Application for Planning Permission for Works or Extension to a Dwelling

Development: Proposed front extension (to replace existing porch/conservatory), rear extension, new roof tiles and render to cover existing brickwork and loft conversion to include front and rear dormers and removal of barn hips to the side.

Location: 8 Laburnum Close Ferring BN12 5EJ

I regret that I am unable to accept your documents as a valid application until the following item(s) have been received or resolved :-

PROPOSED FRONT / REAR EXTENSIONS AND LOFT CONVERSION

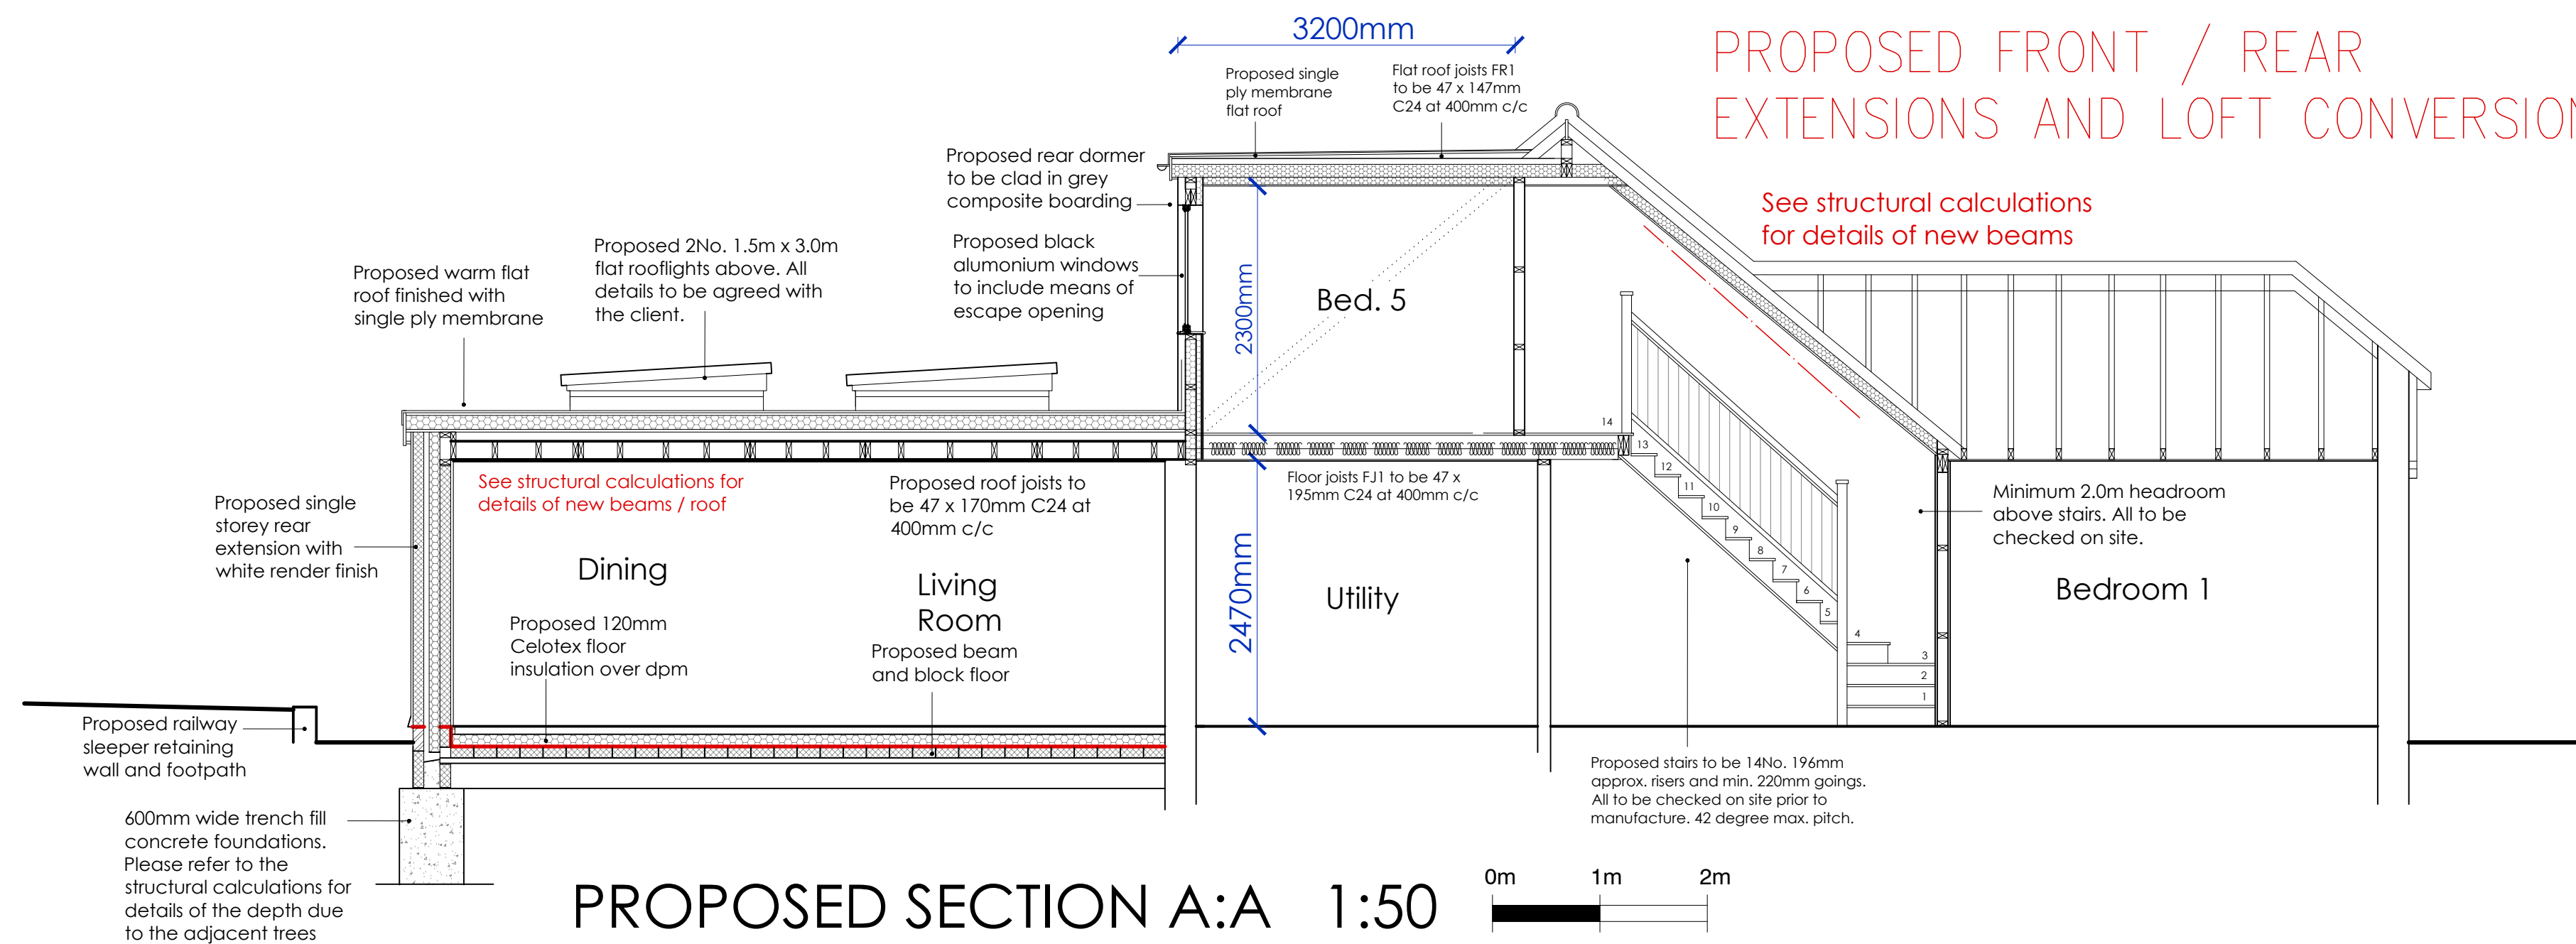
Proposed East Elevation

The proposed east elevation has a 1:100 scale listed, however is measuring to 1:50, please review and amend.
